3. UTILITIES

Attn: Stephen R. Bushey, P.E.
Re: Multi-Unit Commercial Building; 421 Warren Avenue, Portland
Ability to Serve with PWD Water

**Subject: Multi-Unit Commercial Building
Warren Avenue, Portland, Maine
Request for Ability to Serve Letter**

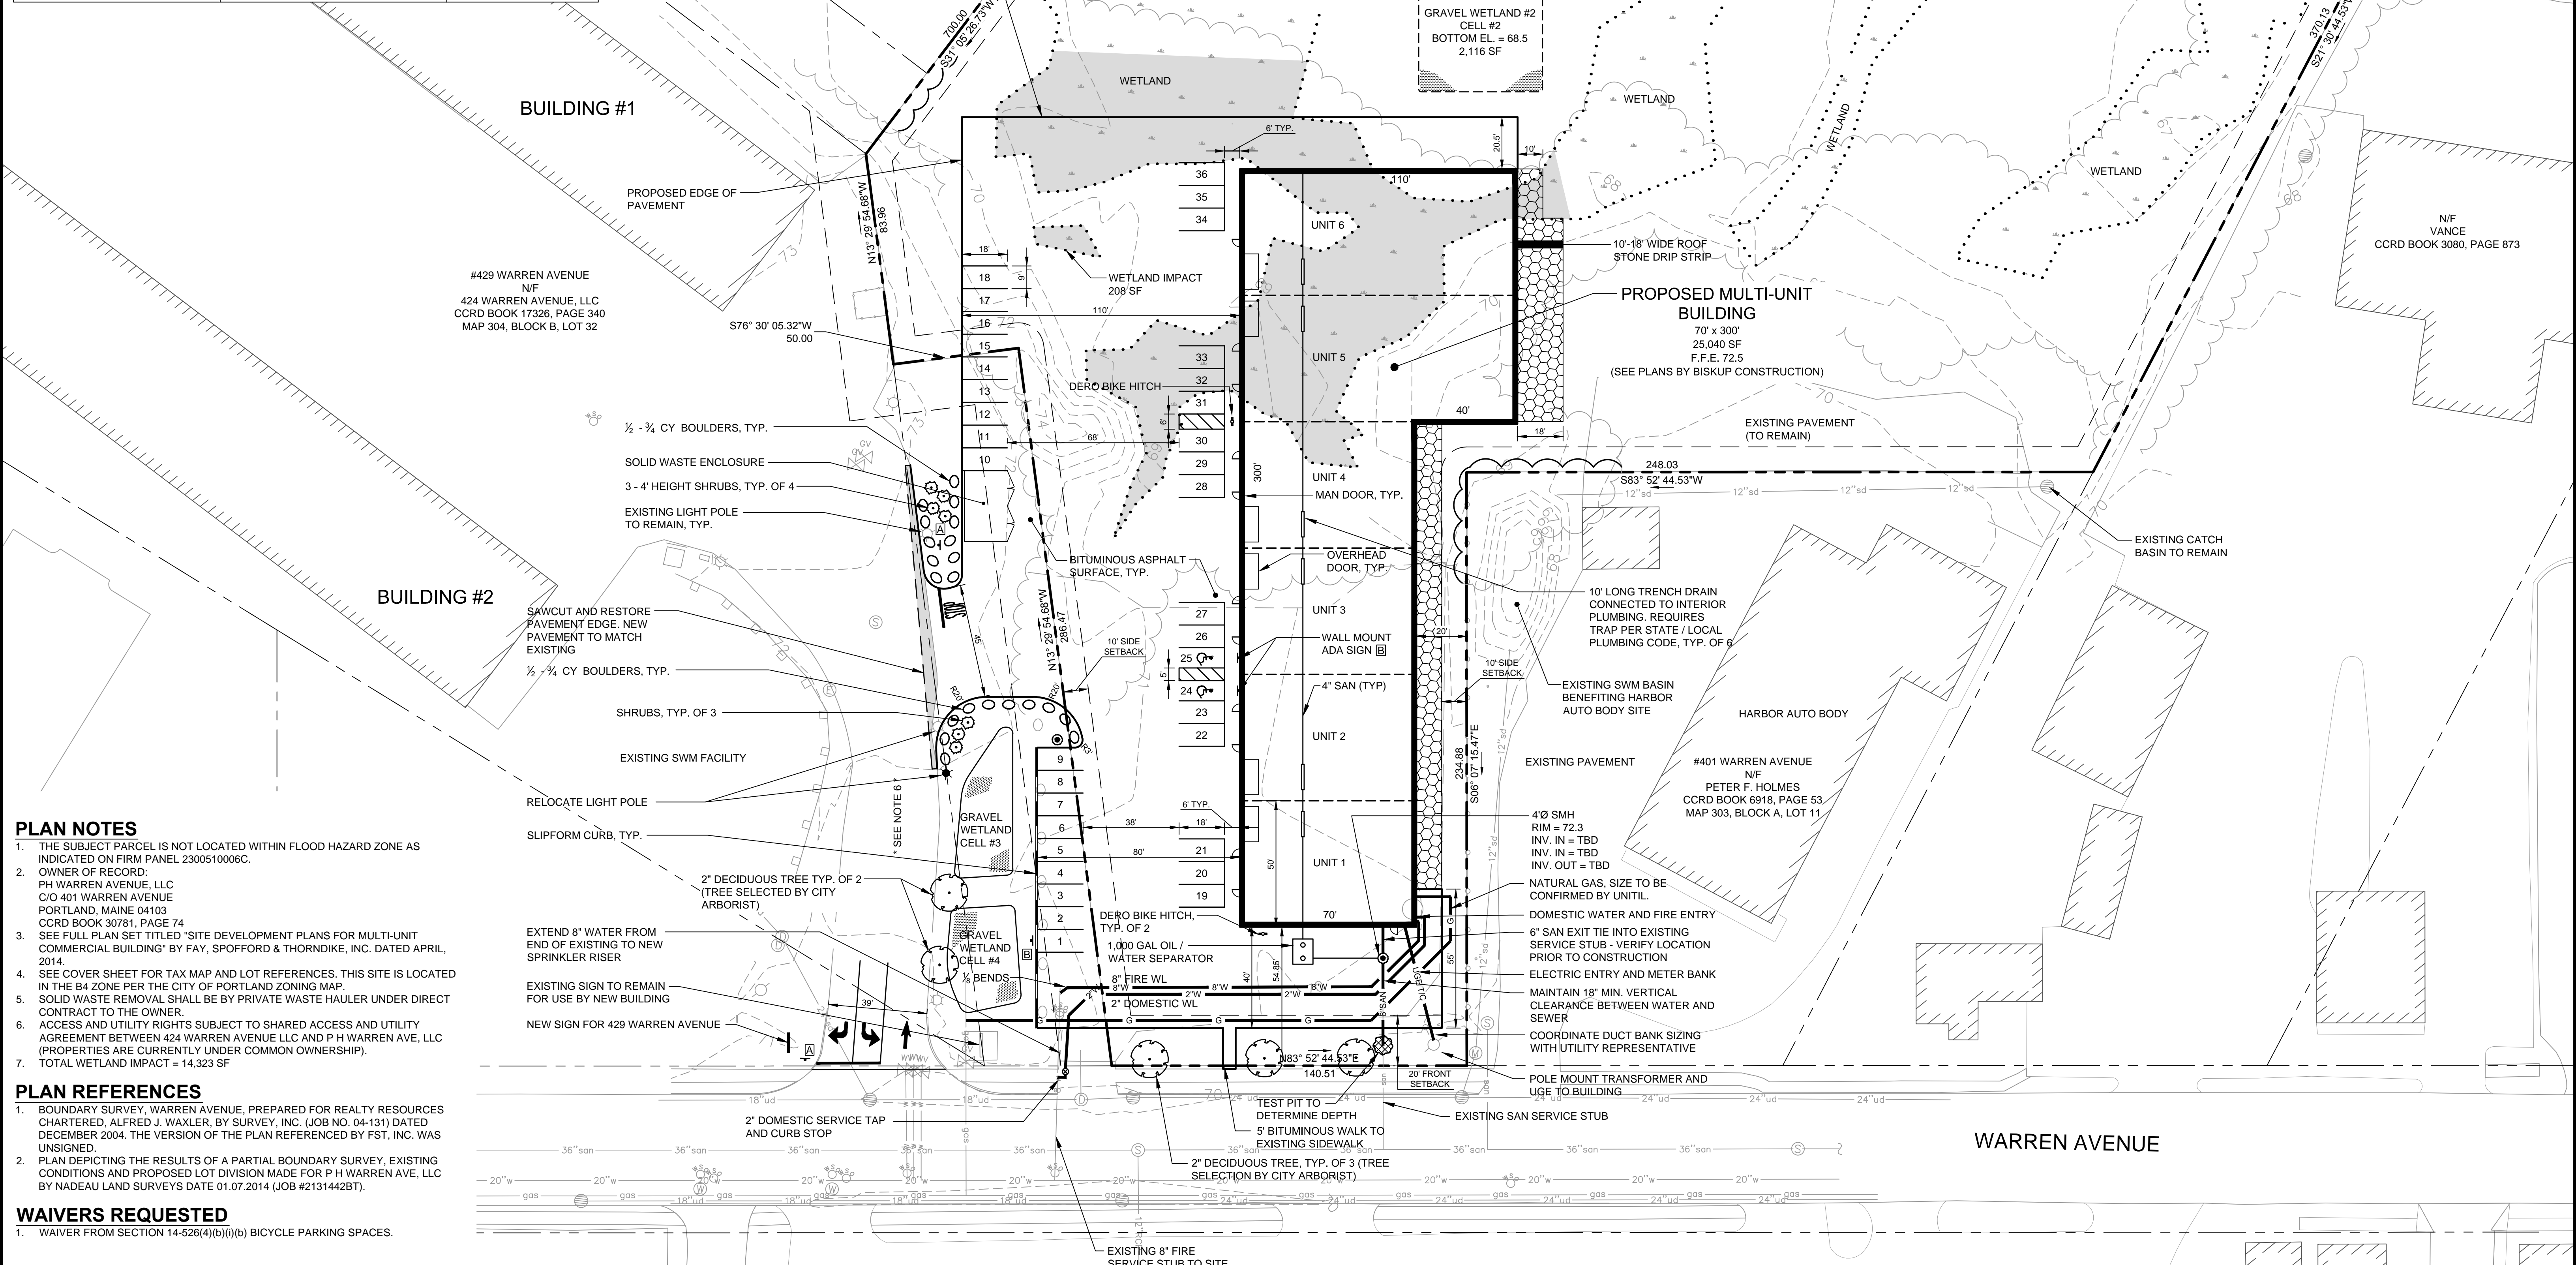
The District can confirm that the existing water system has the capacity to serve the proposed 7-unit commercial complex. We have reviewed the Site Layout and Utility Plan dated February 12, 2014 and have the following comment: Our records indicate that there is an existing 8-inch gate valve on the fire service at the street line. This valve should remain, and the domestic tap should be made prior to this gate valve so that the District will have a control valve on each service, which will allow them to be operated them independently.
